Application No: BR/13/22/HH
Site Address: 235 Hawthorn Road Bognor Regis PO21 2UW
Description of works: Erection of two storey side extension and single storey rear orangery following the demolition of existing rear conservatory and side extension.

Thank you for your internet representation made on 4th February 2022 which has been recorded as an objection with the comments as follows:

REAR ELEVATION PROPOSED 1:100

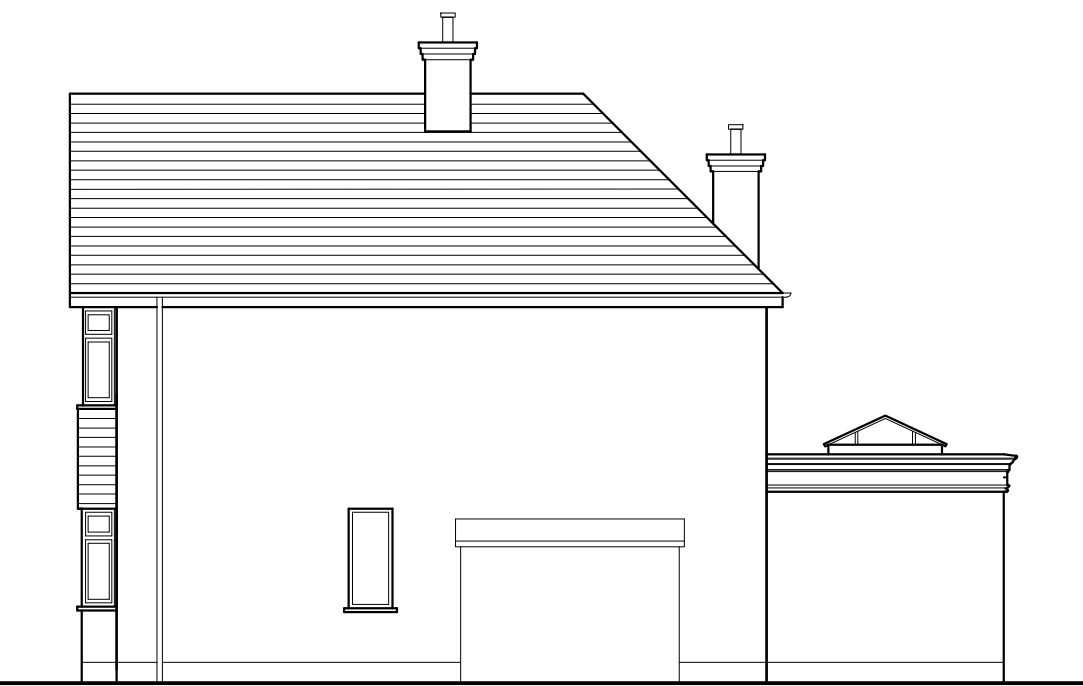
Due to the proposed house being situated on a fairly acute bend on Hawthorn road any windows on the rear of the property at a second story will permit a dual aspect view into multiple homes on crescenta walk. Whereas we have no effected impact from the proposed development in principle we do take extreme objection to the windows on the second story resulting in zero privacy for the kitchen/ family room and garden of our property and many others on crescenta walk.

Concern is raised to further concrete structures affecting what appears to be a fairly high water table already? I hope consideration can be taken in to the application in omitting the windows to the rear elevation on the second story.
